**From:** Contact Centre (CRM) <contact@ribblevalley.gov.uk>  
**Sent:** 06 June 2023 10:39  
**To:** Planning  
**Subject:** Planning Application Comments - Application 3/2023/0378 FS-Case-521773908

**Planning Application Reference No.:** Application 3/2023/0378

**Address of Development:** Pendle road Clitheroe

Drawing Title: Proposed Site Plan with Topographical Survey

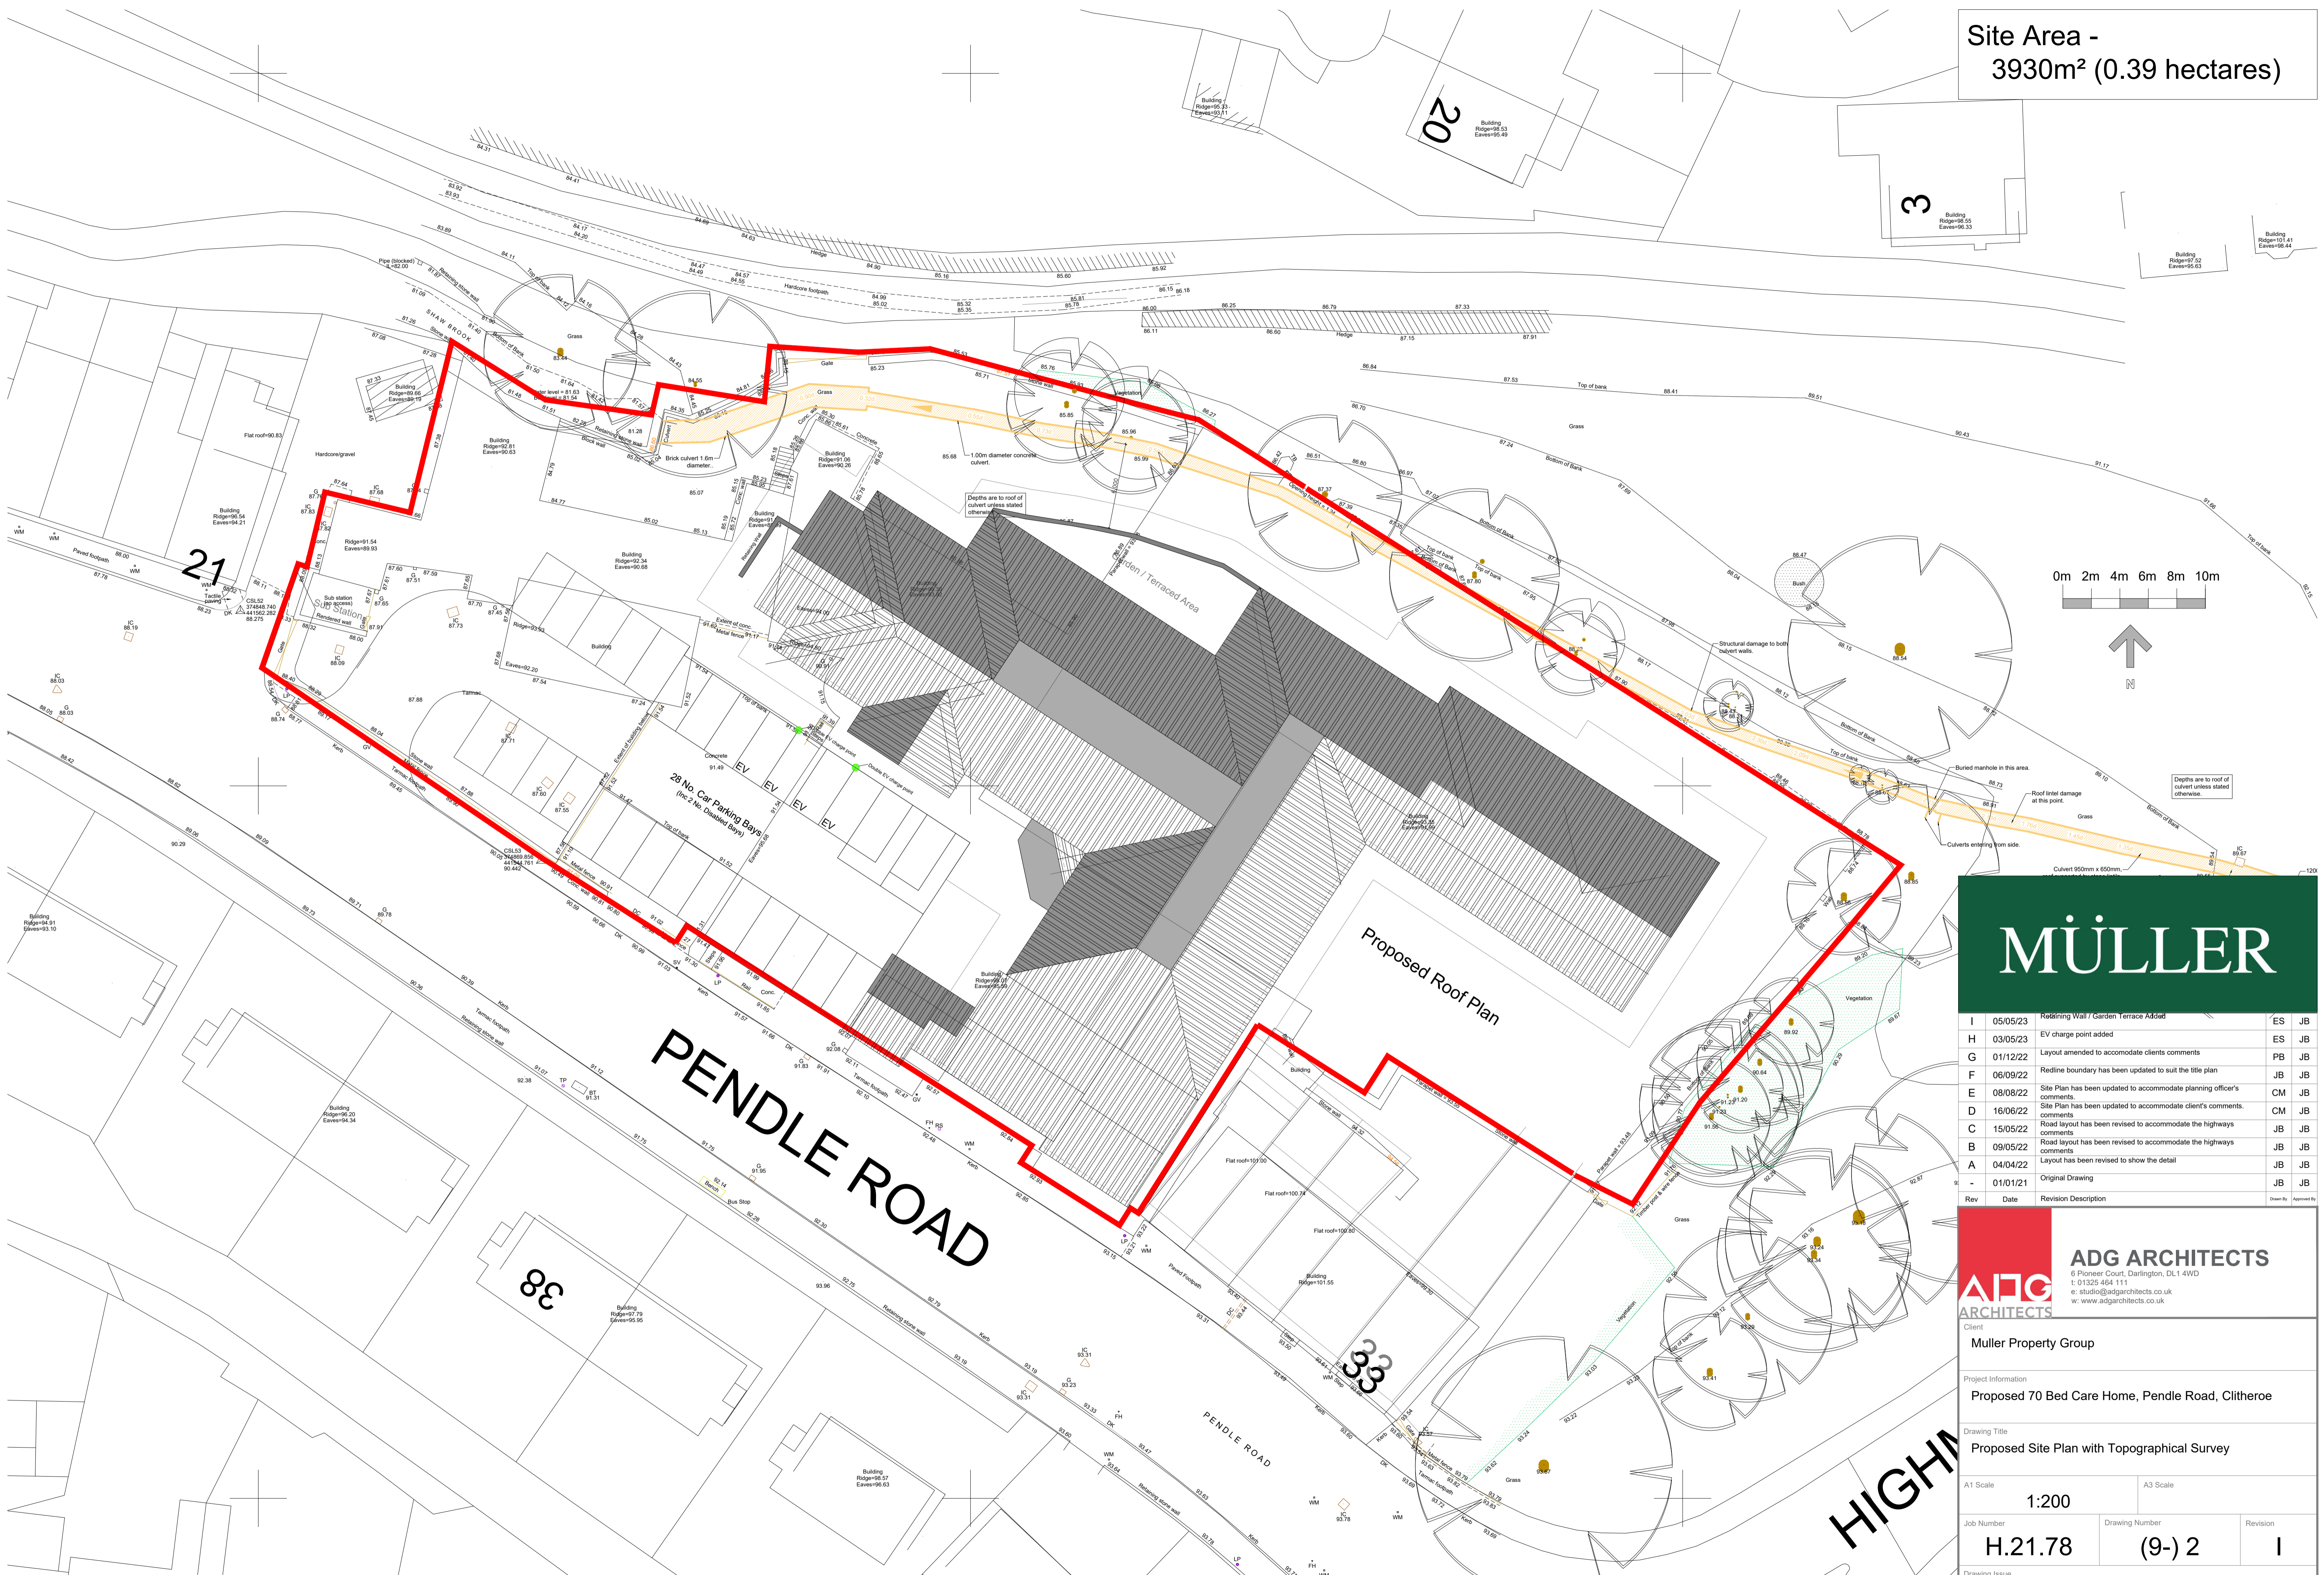
**Comments:** We would like to know where the proposed pedestrian entrance is due to be located and would like acknowledgement that the land to [REDACTED] is not public access and is owned [REDACTED] (the design and access statement states 'The nearest neighbouring properties to the proposal site are on the west boundary, a row of six residential properties sit close to the western access point into the site with their vehicle access along the site boundary.' We have had several people trespassing [REDACTED] who have been involved with the re-development and none of them have been aware that the land is privately owned.  
We would like the developer to provide detailed information about the boundary planting which informs us how high the shrubs will be and if they will afford us privacy and security.  
We would also like to remind the developers that any access [REDACTED] needs to be agreed beforehand [REDACTED]
